Our Ref: R/2022/27
File No: 2022/611104
Your Ref: SSD-35962232

Advice on Environmental Impact Statement – Burrows Road Multi-Level Warehouse – 1-3 Burrows Road, St Peters

Thank you for your correspondence dated 16 November 2022 inviting the City of Sydney (the City) to comment on the Environmental Impact Statement (EIS) submitted for the Burrows Road Multi-level Warehouse proposed at 1-3 Burrows Road, St Peters.

Drawing title
PLAN OF DETAIL AND LEVELS OVER LOT 11 IN DP 606737
AND LOT 1 IN DP 1227450 KNOWN AS 1-3 BURROWS ROAD
ALEXANDRIA

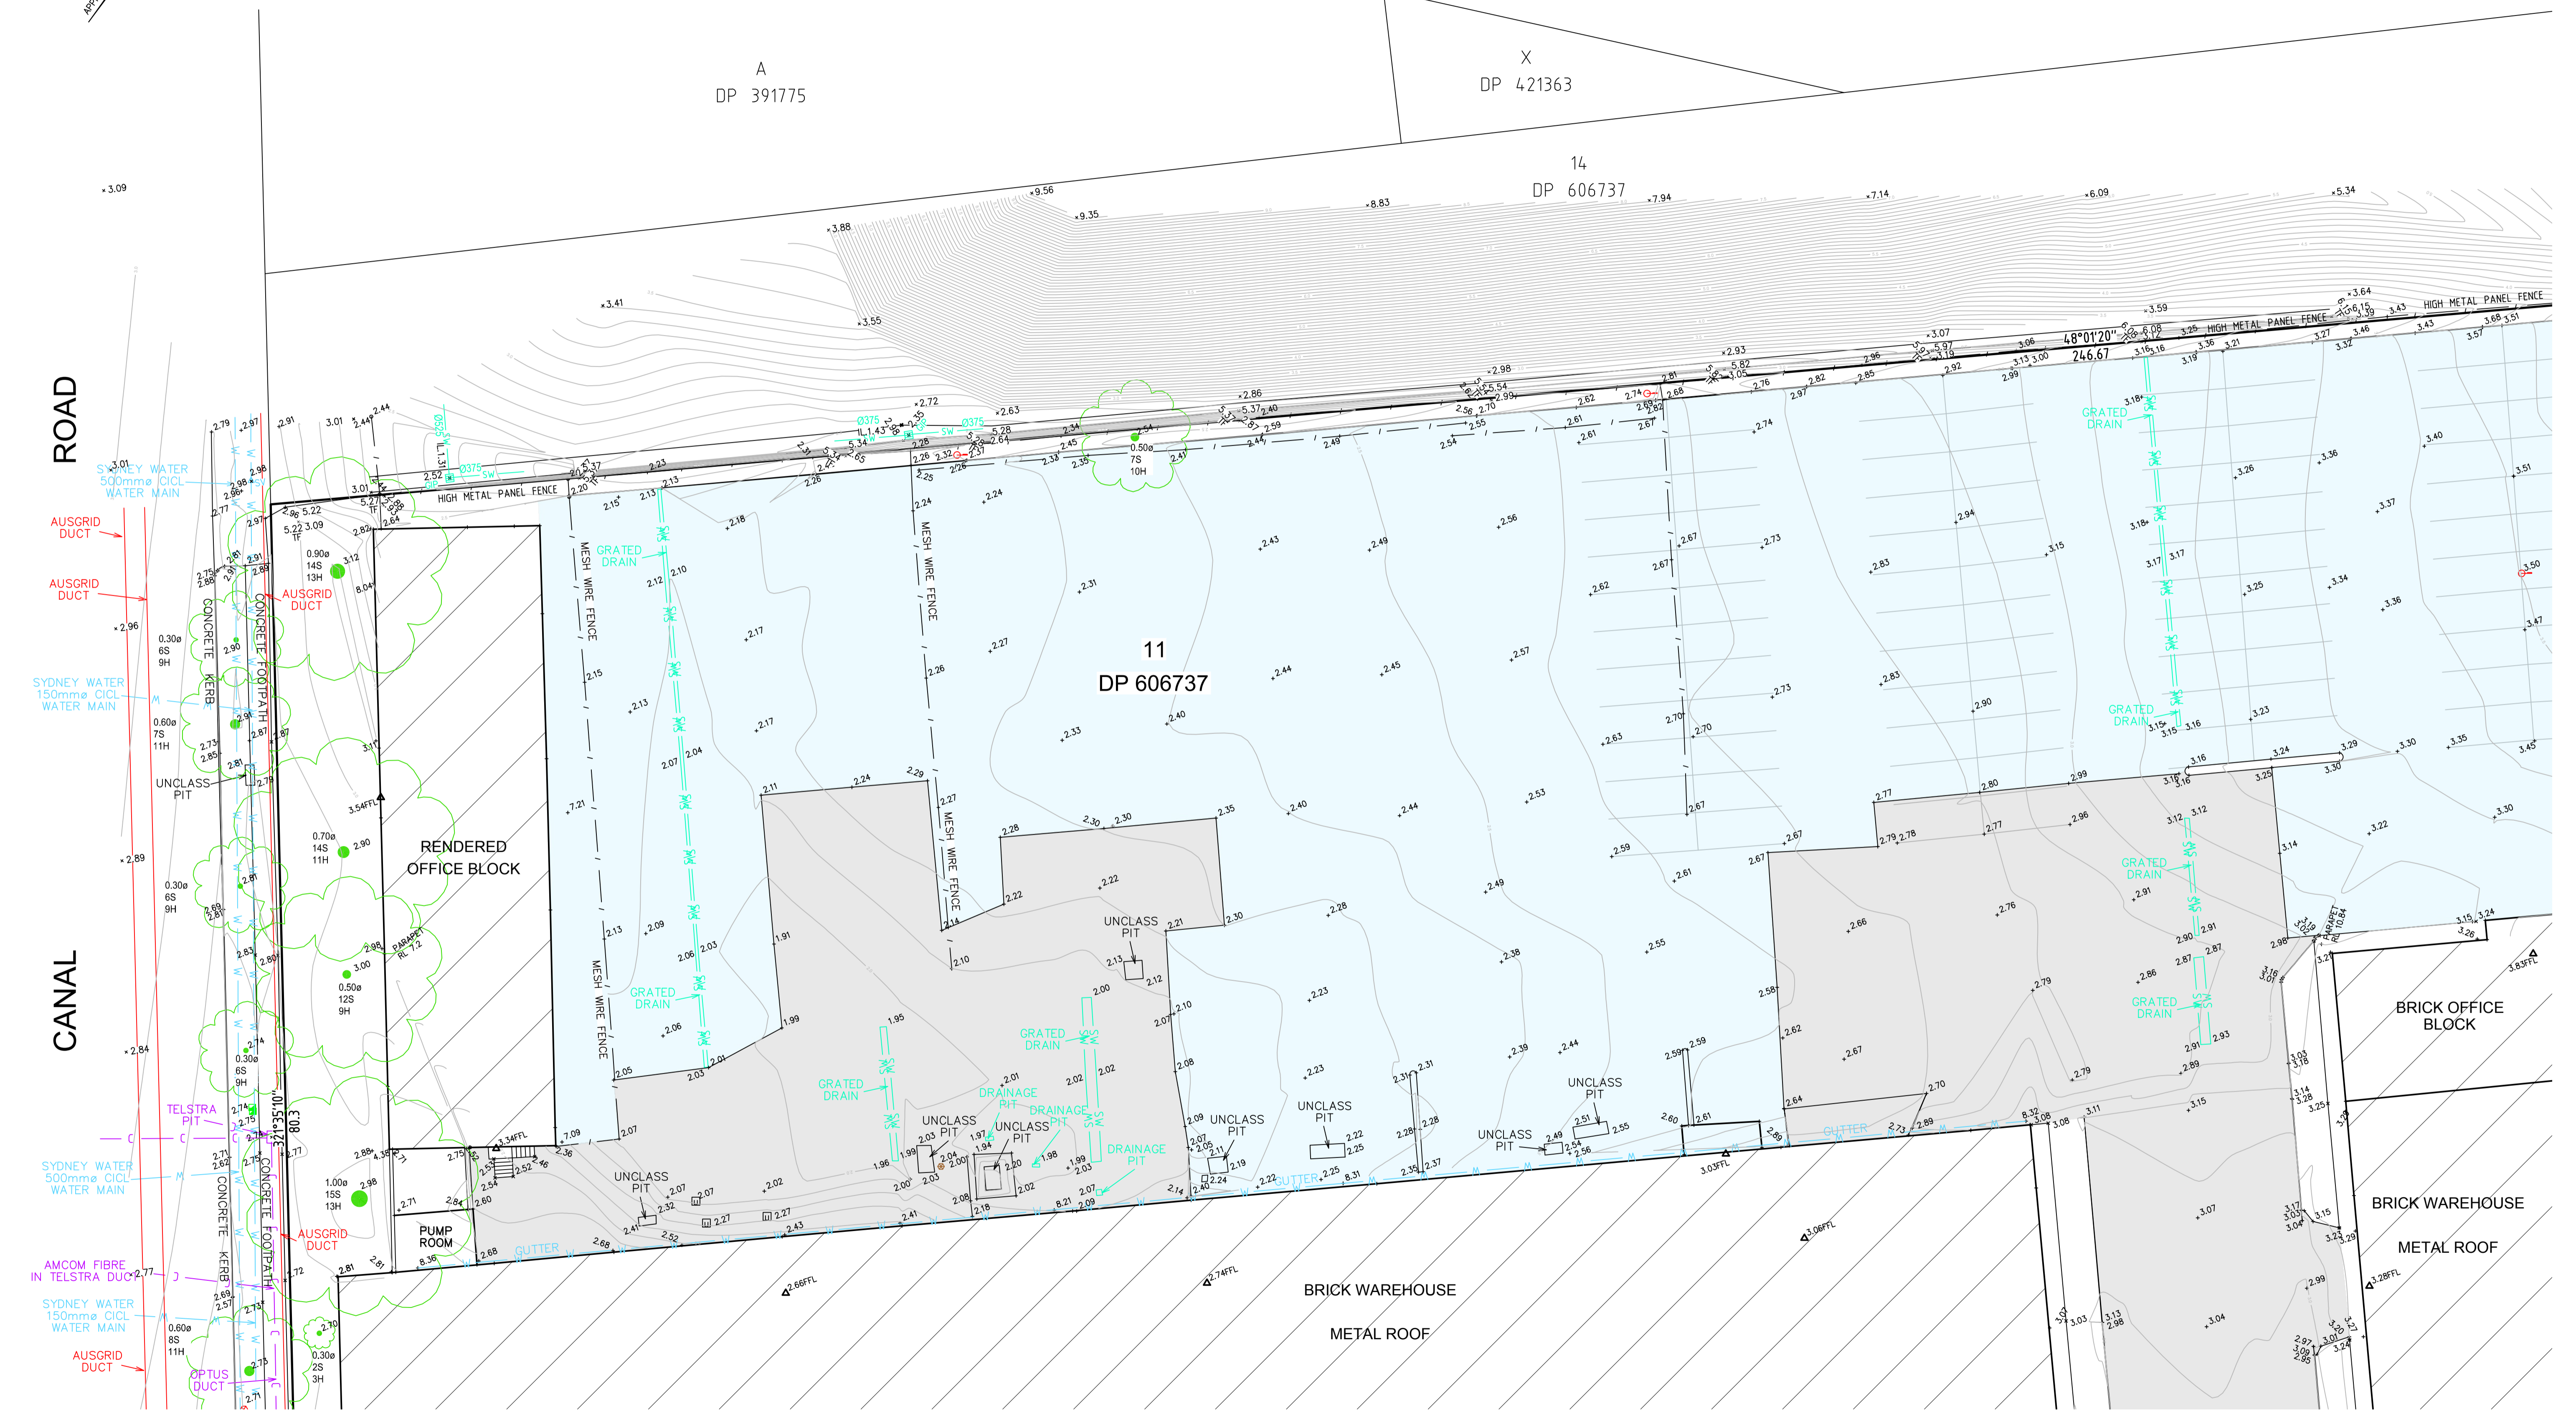
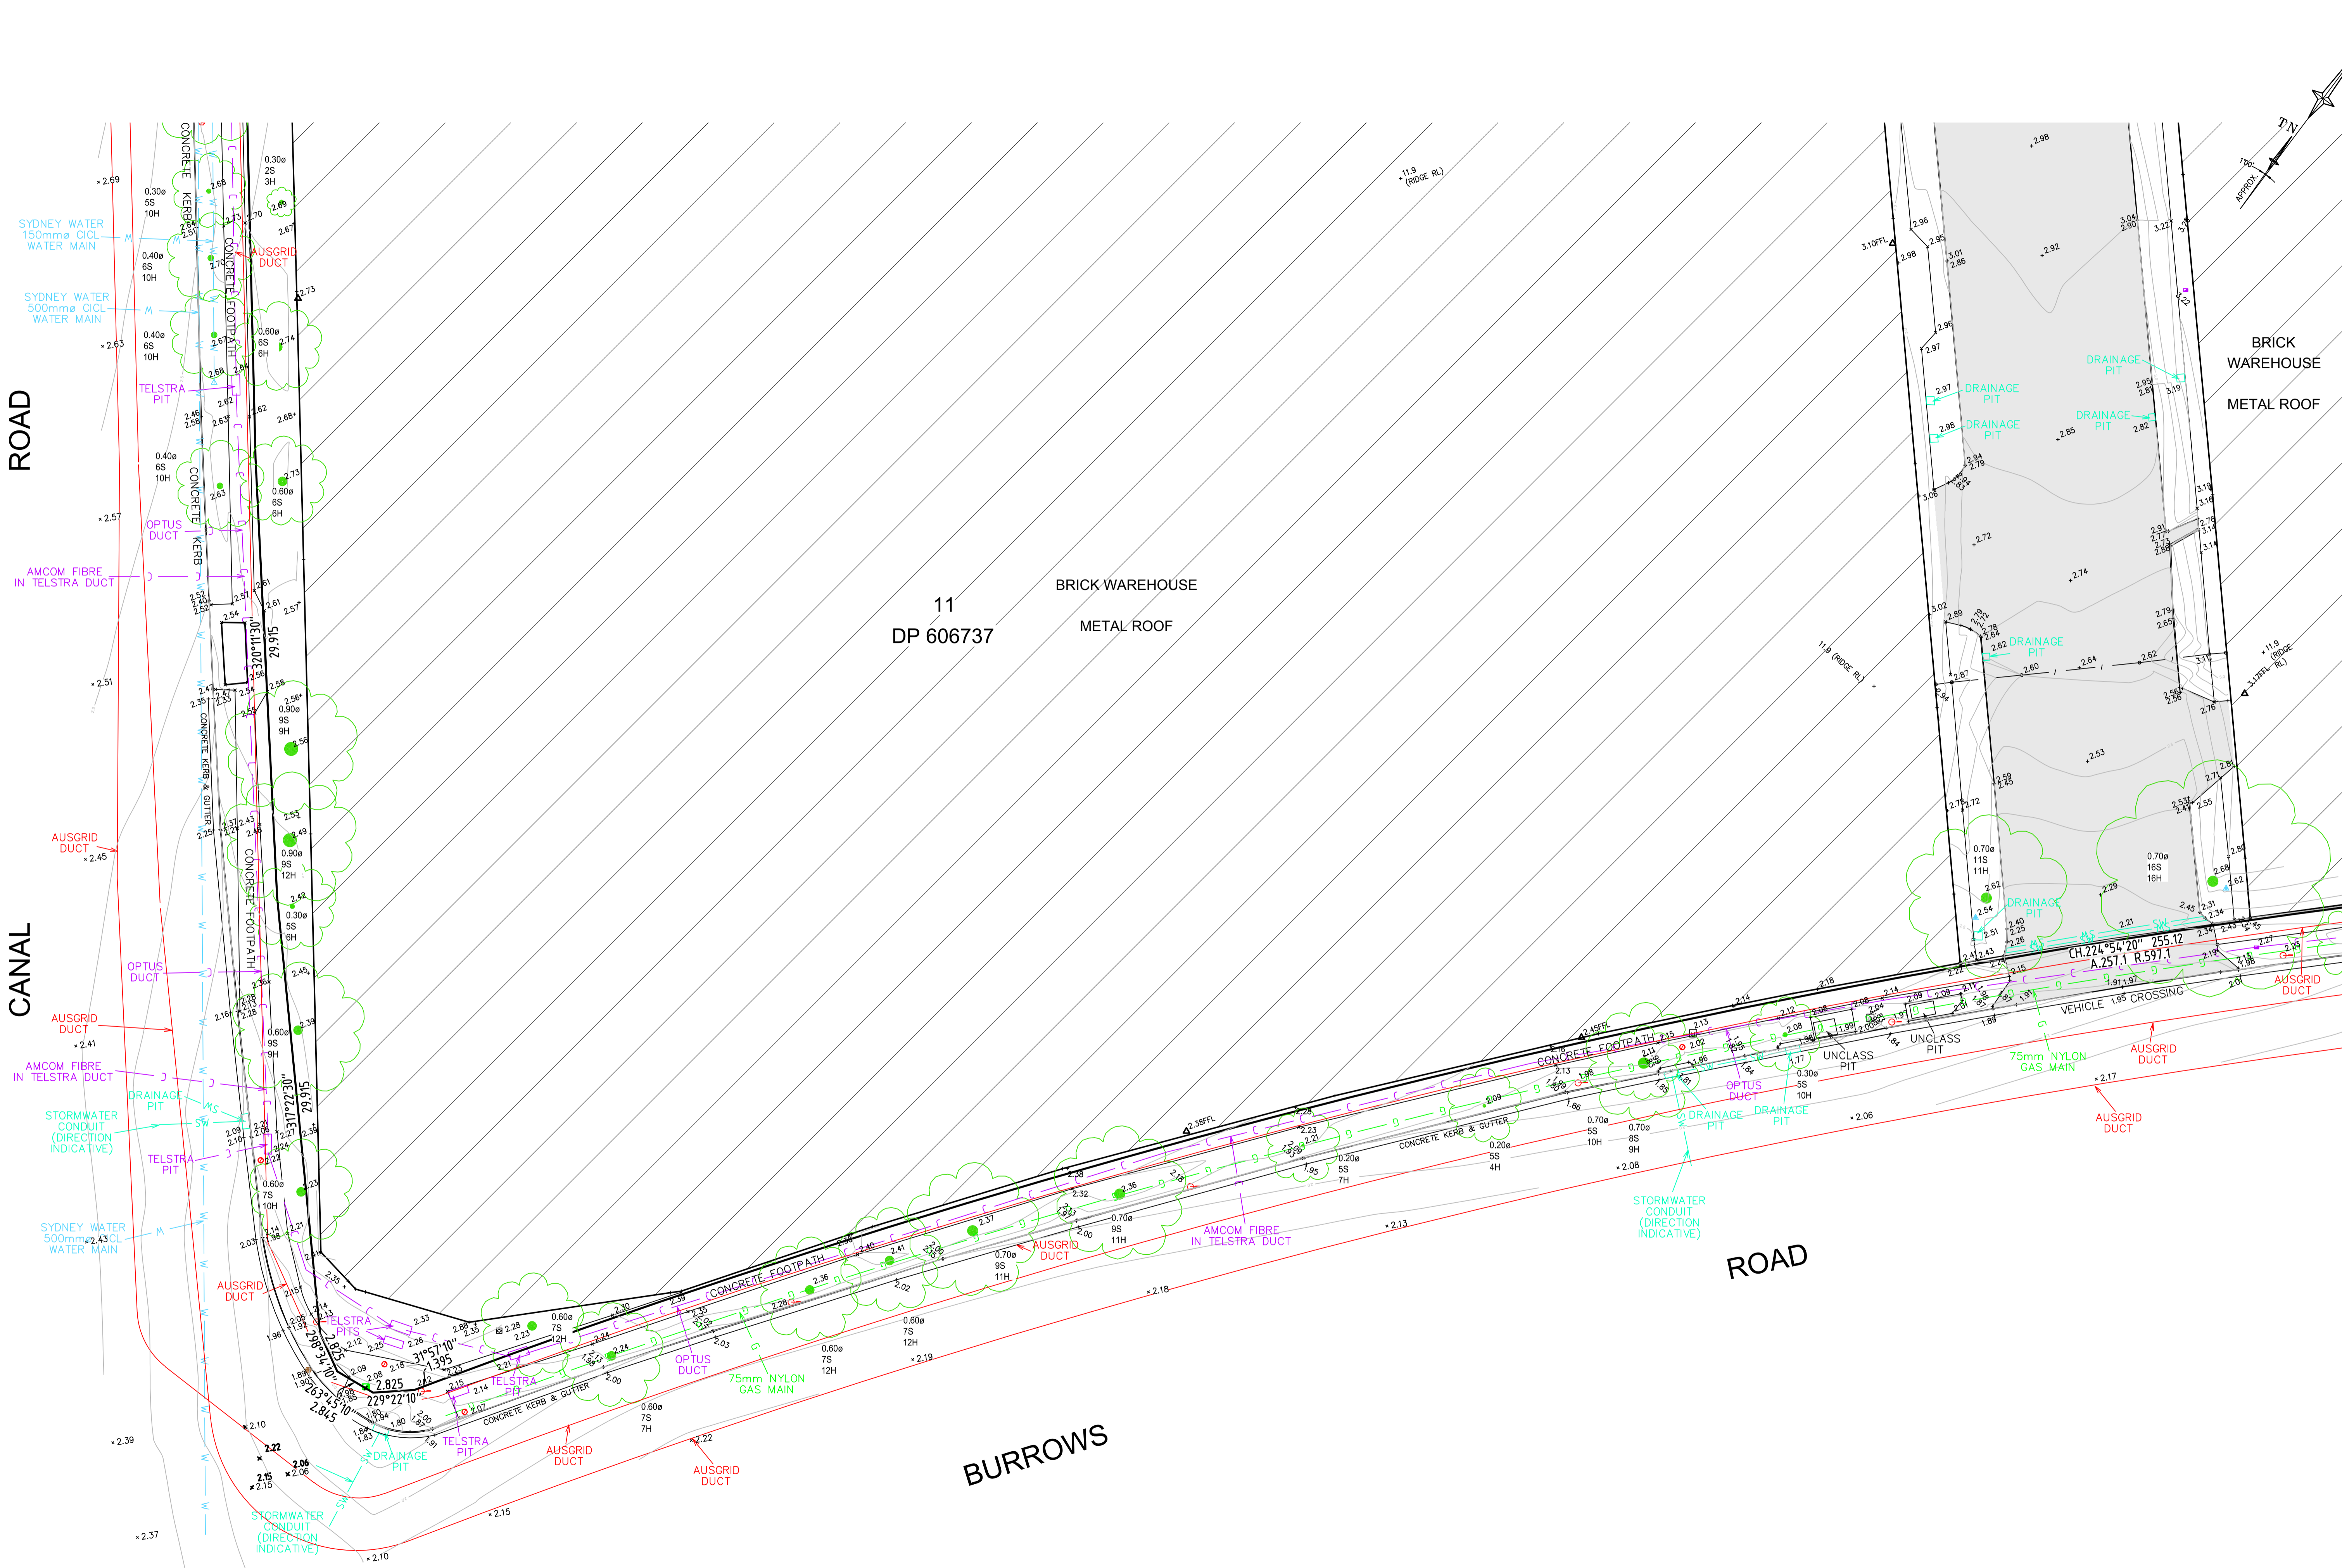
The survey indicates that the total site area is approximately 32,720sqm whereas the EIS states that the area is approximately 34,614sqm. Clarification of the actual site area is required.

DRAWING TITLE
STORMWATER DRAINAGE PLAN
DRAWING No
C011035.04-SSDA4.0
ISSUE
C

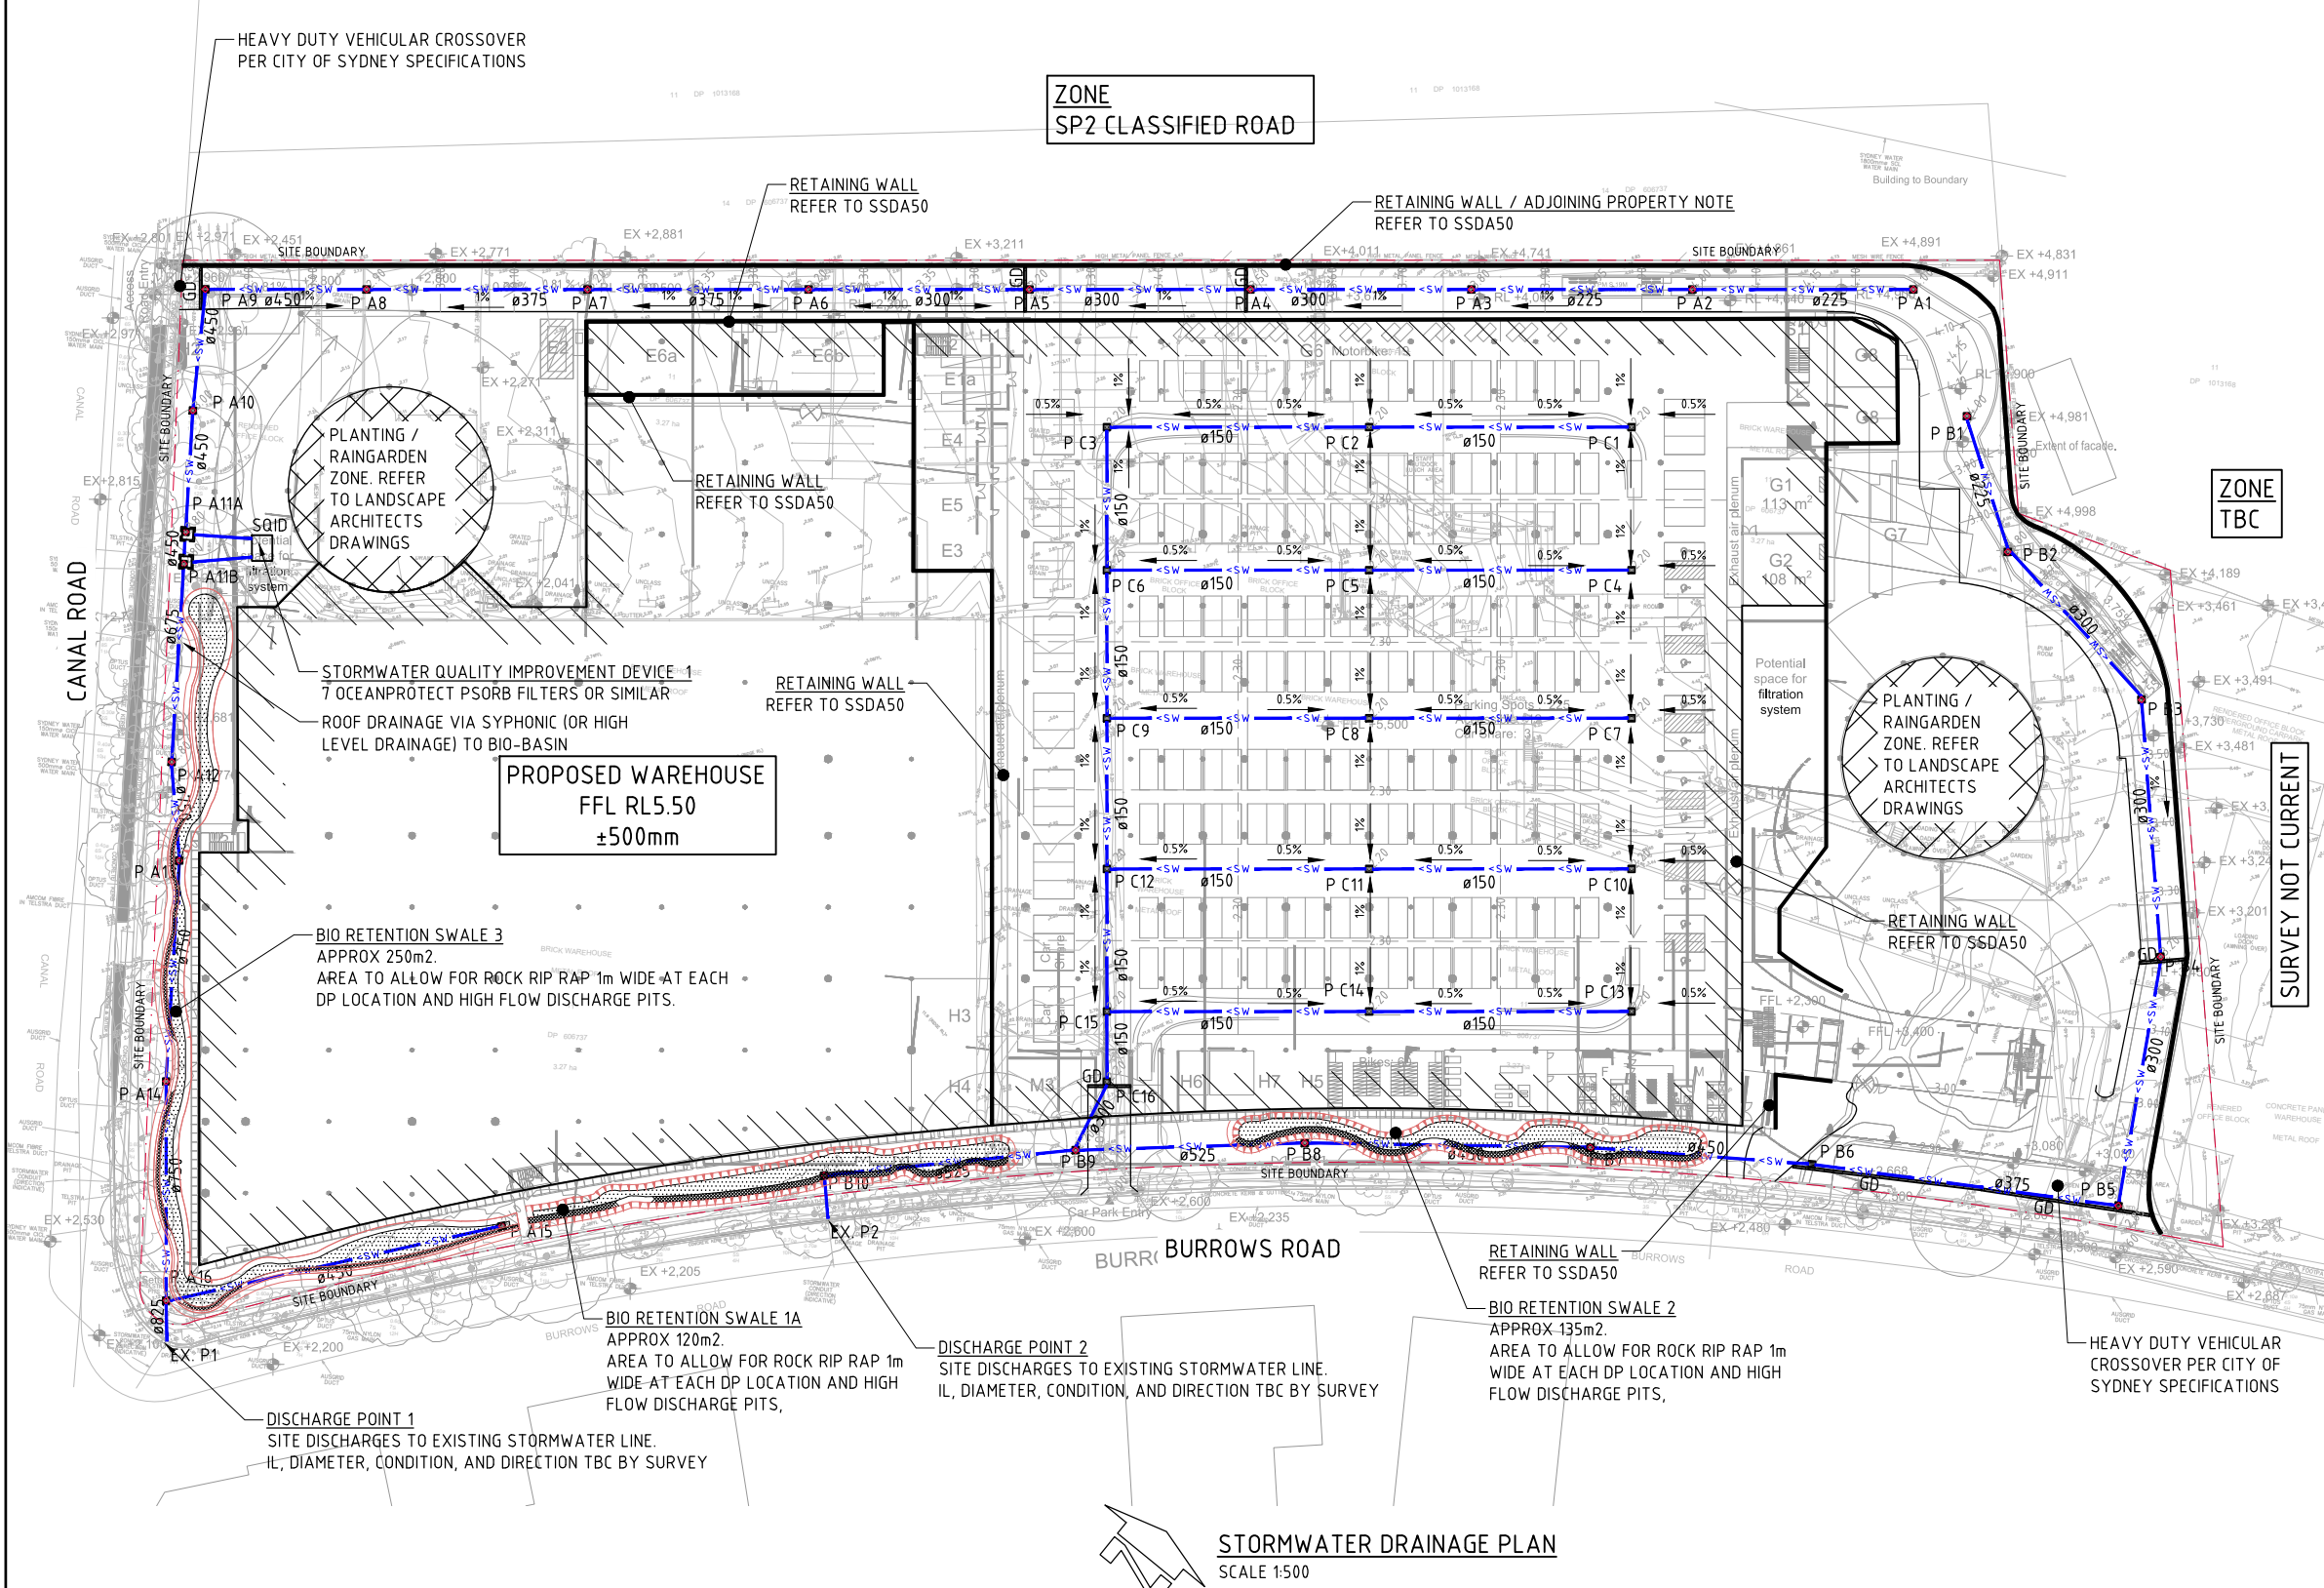
A review of the civil plans indicate the 6 metre landscape setback is significantly impeded by stormwater pits and 450mm diameter pipes, as well as three long curved 1

metre wide bioretention swales lined with rock rip rap. The bioretention swales are 120 to 135m long on Burrows Road and up to 250m long on Canal Road (Fig 1 below).

- It is unclear whether the 500mm depth bioretention soil filter media detailed by the engineer needs to be removed and replaced in the future to maintain effectiveness as a drainage device.
- Whether the civil design considers remediation of site contamination in the landscape setback.
- It is unclear if the stormwater design has been coordinated with the landscape design and tree placement and if there is adequate soil volume to support the trees to maturity.

The applicant is requested to submit an engineer's report to clarify the design and requirements including remediation. The City also requests landscape plans at a legible scale, black and white that clearly demonstrate coordination and resolution of the landscape setback, location of trees, levels (IL, RL, TW) and confirm the permeable pavement specification and detail.
